THOMSON
ADSETT
ARCHITECTS

12 November 2008

RE: **MP 08_0073 – NARRABRI DISTRICT HEALTH SERVICE REDEVELOPMENT
RESPONSE TO ISSUES RAISED**

Agreed Concept Site Plan Roof Plan

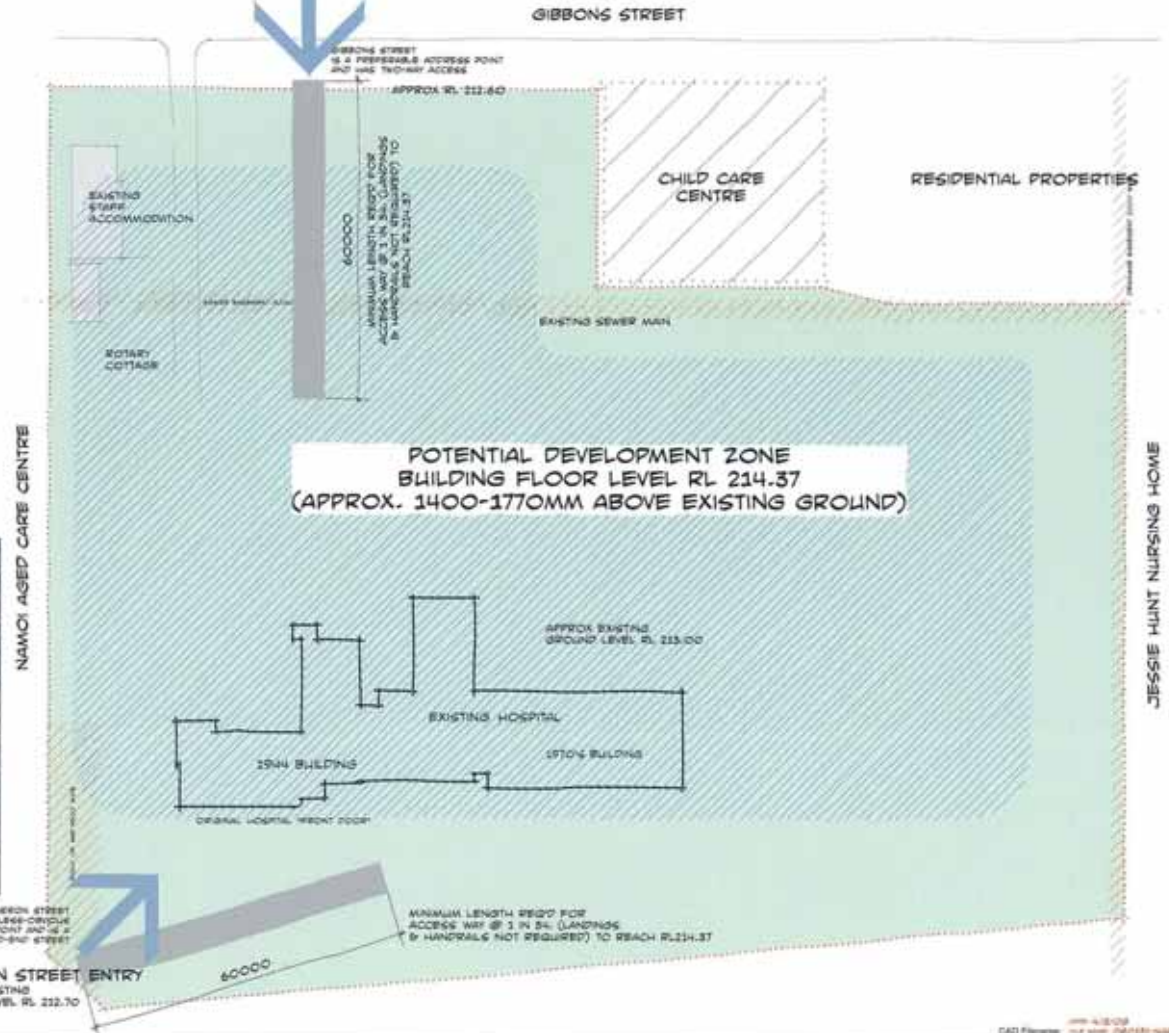
1 & 2 Pre-lodgement discussion indicated a strong desire by authorities to minimise traffic using Cameron St and this has been done. Cameron Street remains an emergency access point with a sealed, all-weather road, controlled by a gate. Main Ambulance access is via Gibbons Street.

3 The main entry road system will be clarified with signposting and road marking.

4 The roundabout will be formed with a concrete roll kerb to ensure access is available in any situation.
